Meeting note

Project name	East Midlands Gateway Phase 2 and East Midlands Gateway Rail Freight Interchange Material Change
Case reference	BC0410001 and TR0510002
Status	Final
Author	Planning Inspectorate
Date of meeting	30 September 2025
Meeting with	SEGRO Properties Ltd and SEGRO (EMG) Ltd
Venue	Microsoft Teams
Circulation	All attendees

East Midlands Gateway 2 DCO application

Section 51 advice for applicant relating to documentation as to submission dated August 2025

# Appendix 6d.6 – ES Link ID Locations Around A42 Tonge Interchange

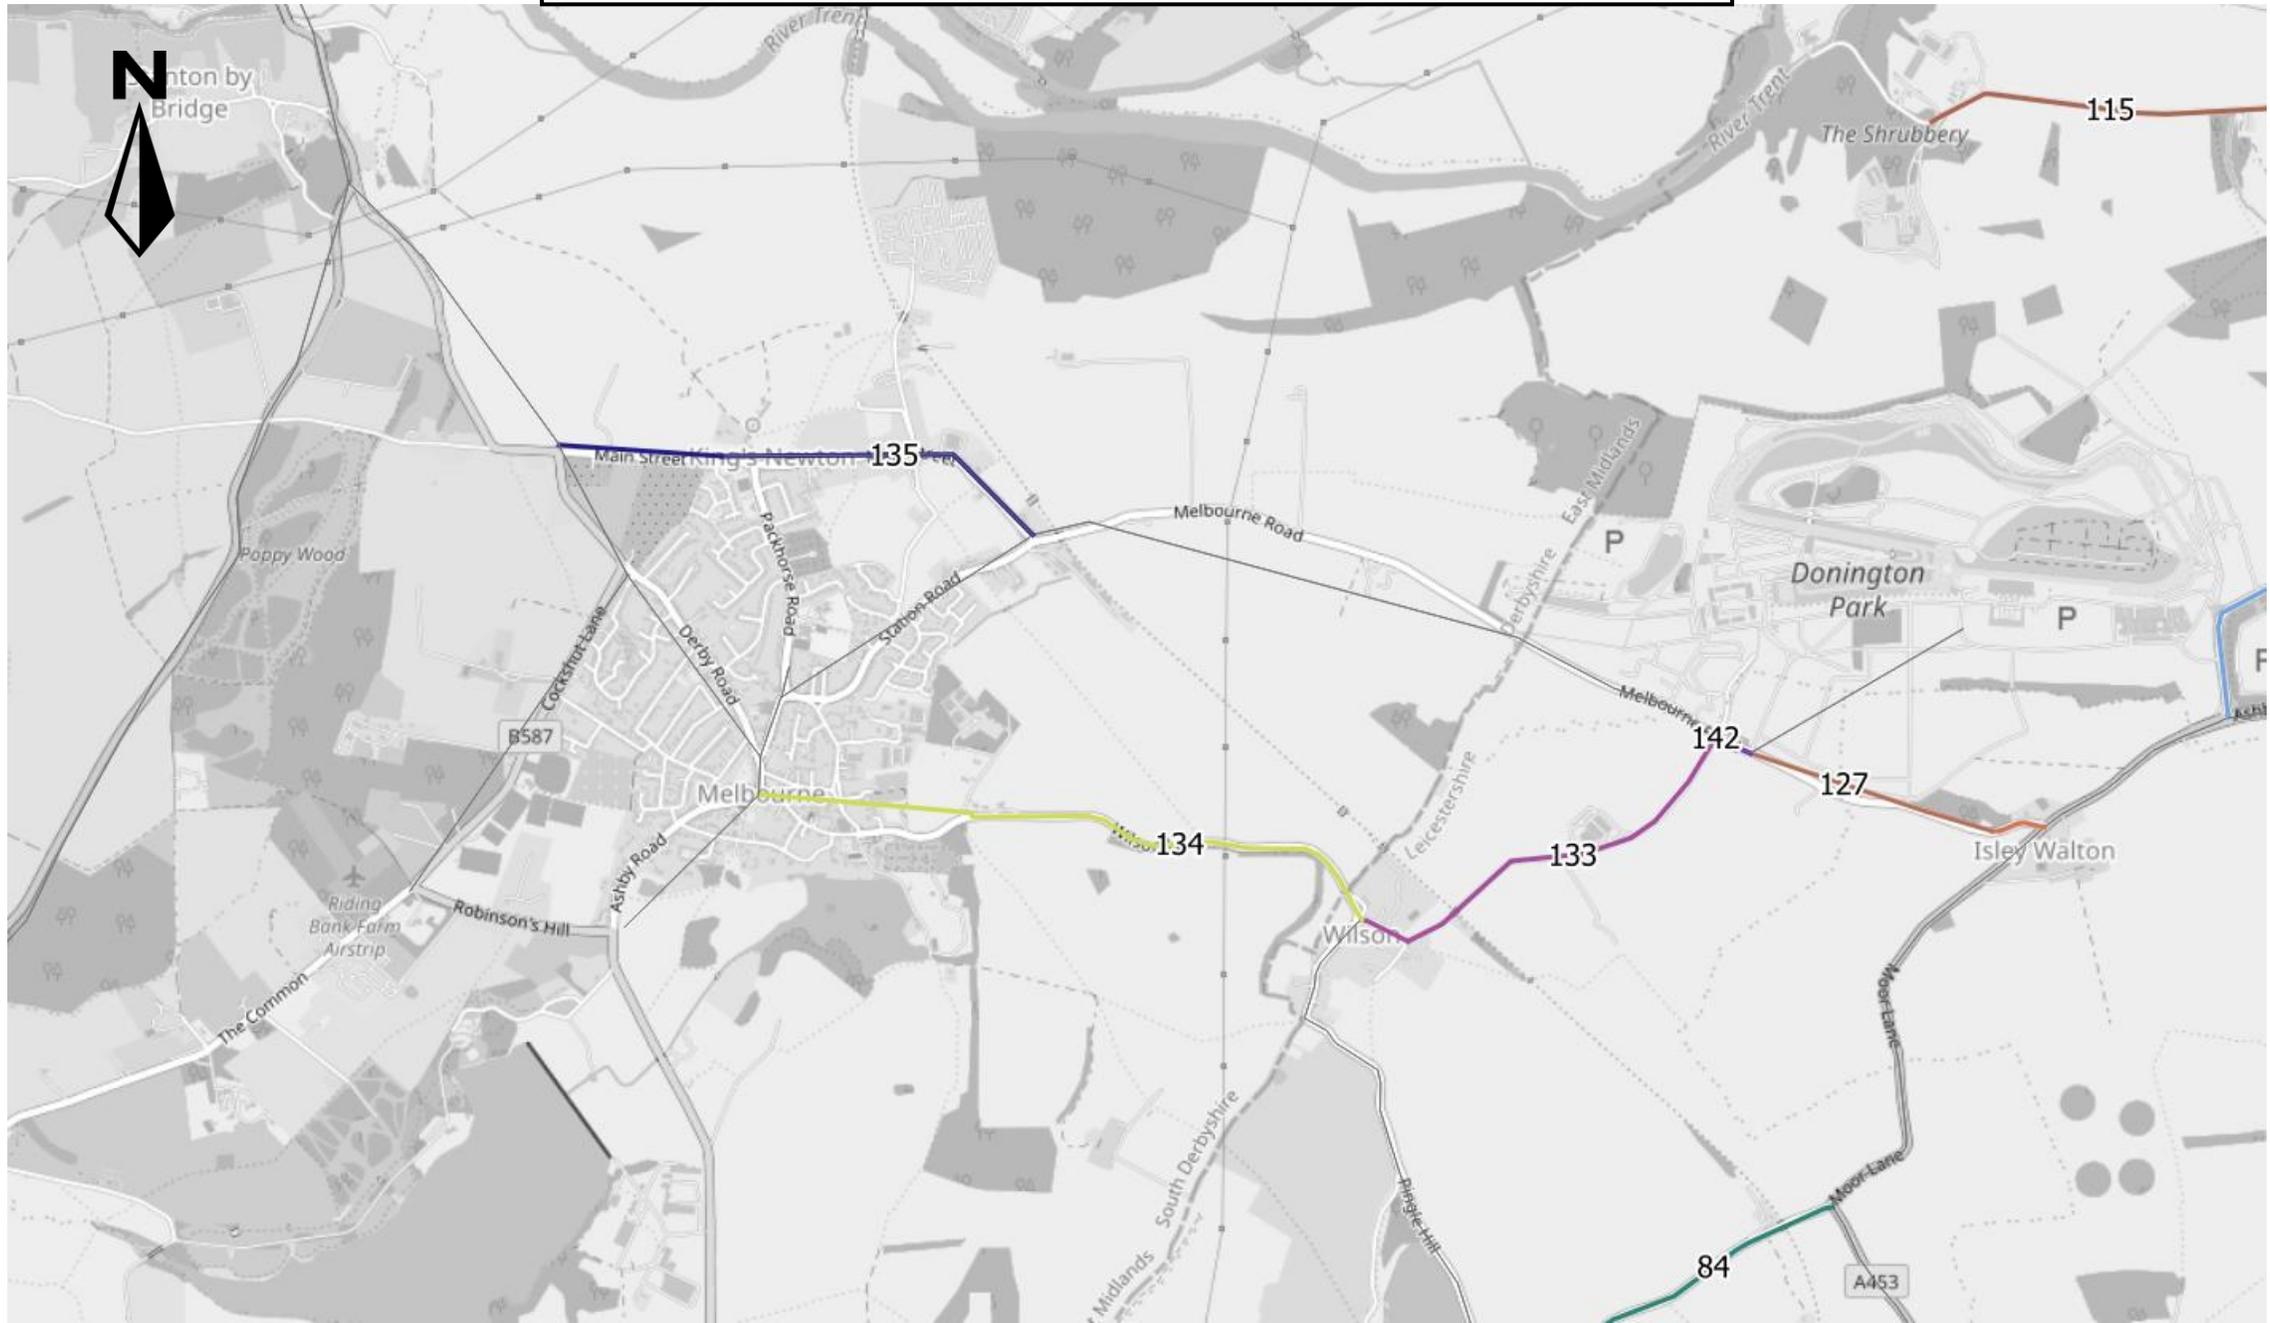
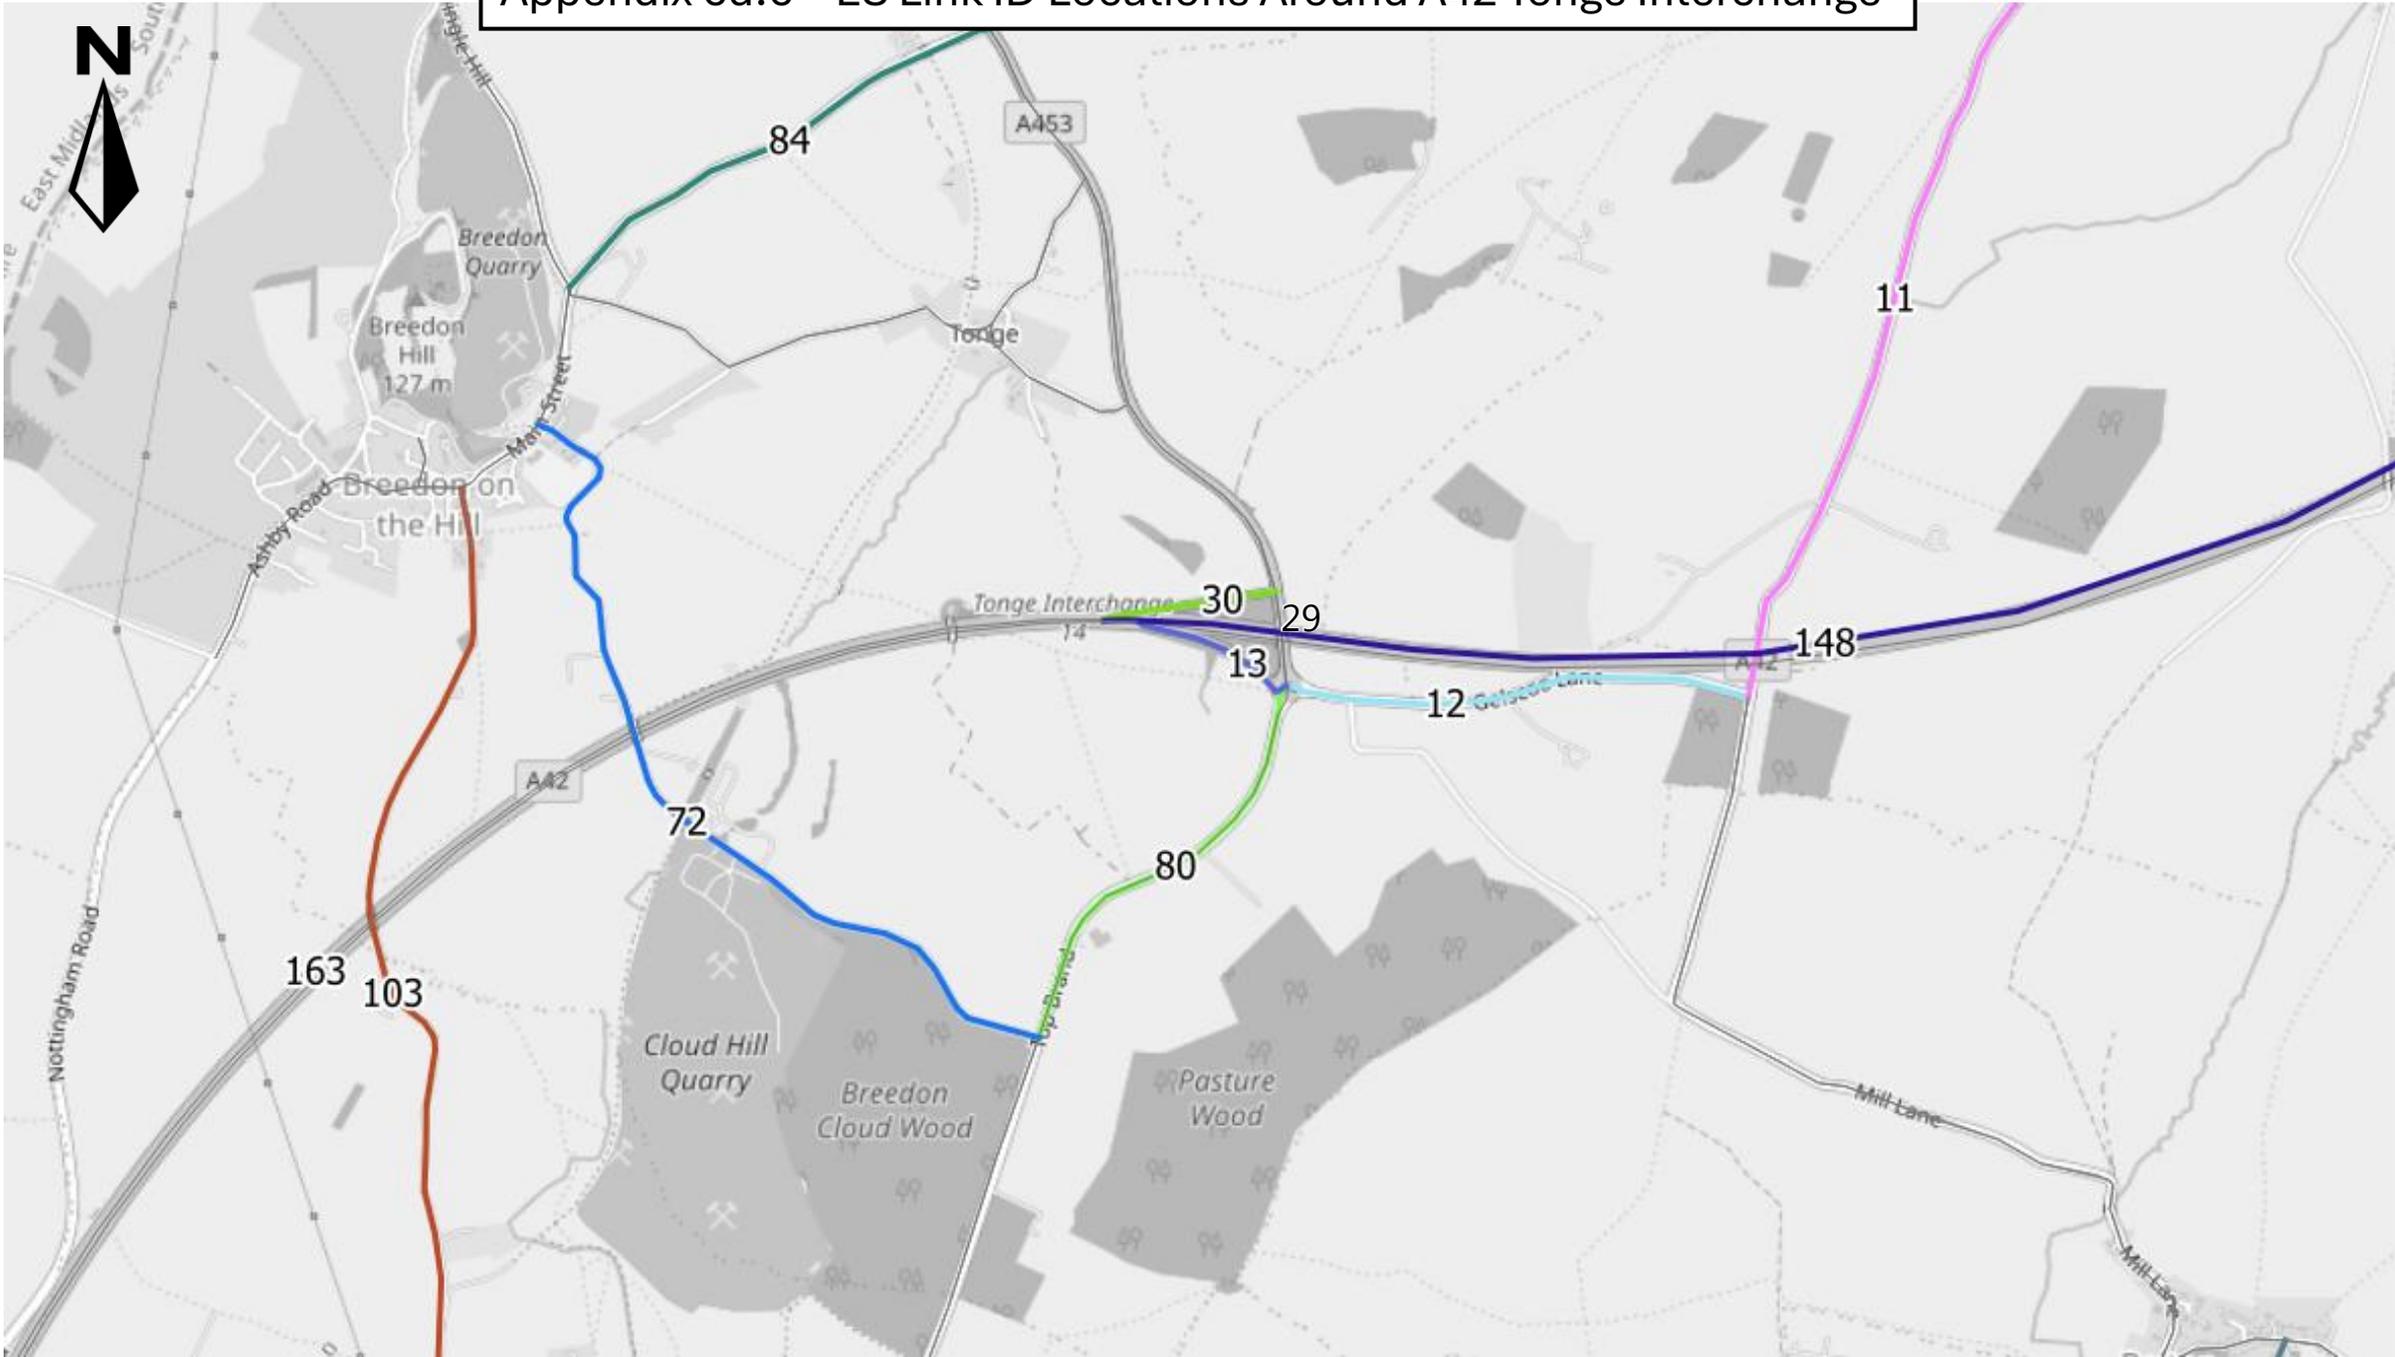
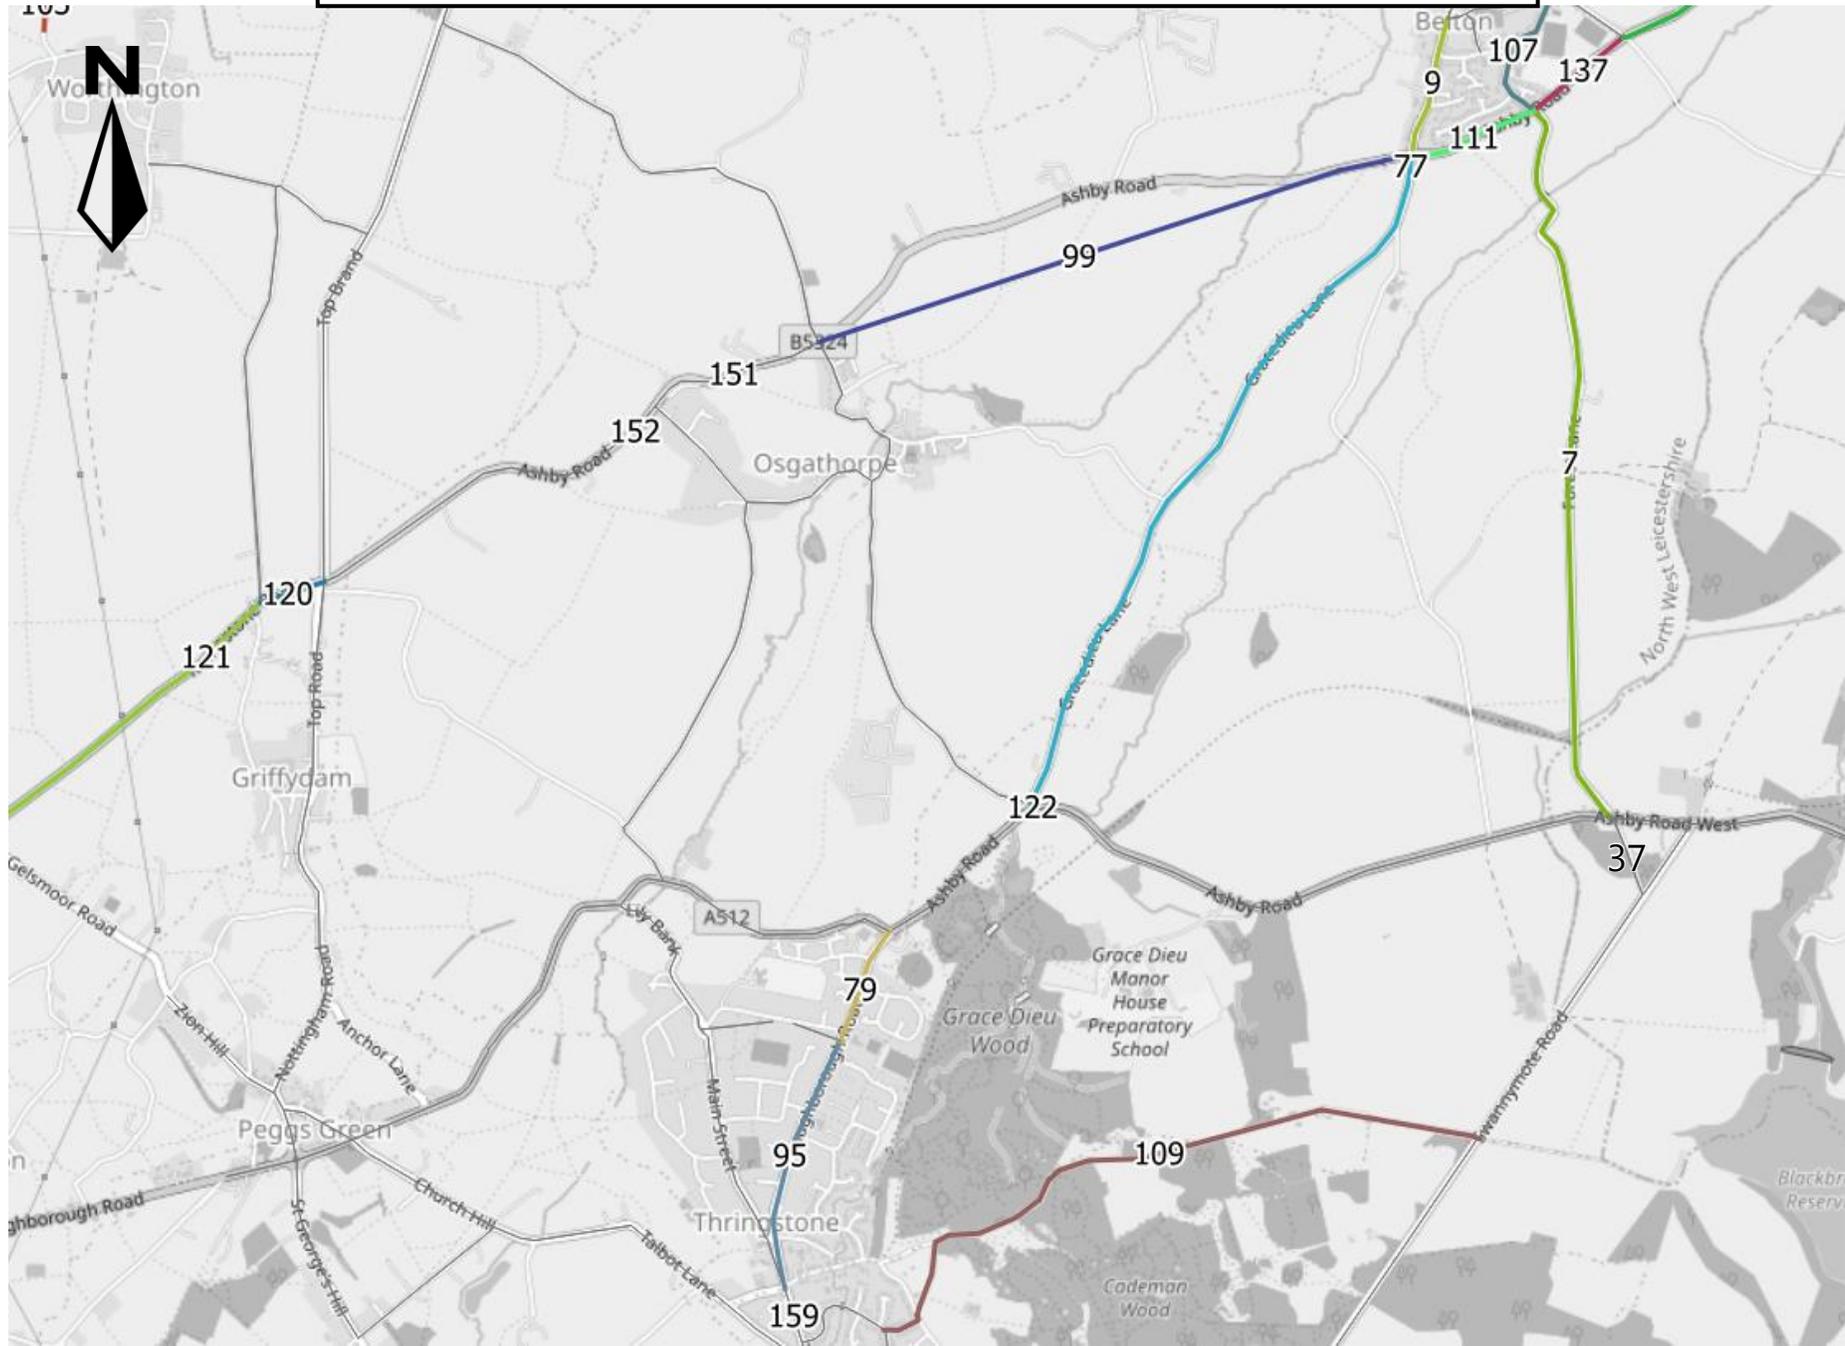
The Inspectorate identified within the transport assessment (TA), and also Chapter 6 of the Environmental Statement (ES), references to routes / links, however the precise location of these is not clear.

Issue	Potential Resolution
<u>Transport Assessment</u>		
1.	<p>Within the Transport Assessment (TA) and chapter 6 of the Environmental Statement (ES) there are numerous routes/ links which are referred to. However, it is not clear the precise locations of these or the extent of the routes/ links.</p> <p>Examples include:</p> <ul style="list-style-type: none"> • Tables 25, 26, 28, 29 and 30 of the TA • Paragraph 6.6.9 of chapter 6 of the ES refers to various links, purporting to show them in a figure in Appendix 6D. However, Link 6 is said to be Long Street, Belton which is not shown. There is a link “6” in Diseworth (given there isn’t a link “9” this may be upside down). The extent of link 28 also is not clear, and Link 54 (see Table 6.8) appears to be missing from Appendix 6D, and there are two links identified as ‘Link 20’ in the key. • Tables 6.9 and 6.14 of chapter 6 of the ES. <p>Furthermore, Tables 25 and 26 of the TA have as their first column titles ‘Counter location’ but all are times.</p>	<p>Provide plans based on Ordnance Survey at no greater scale than 1:10 000 showing full extent of all links referred to. This may involve redrafting documents such as chapter 6 of the ES, its appendices and the TA, to ensure all routes/ links are fully identified. Ensure tables have appropriate identifiers.</p>

The applicant explained that it shall refine this information into smaller segments and provide further clarity regarding the 172 links identified. The Inspectorate noted that the applicant should make this information clear and comprehensible for all stakeholders.
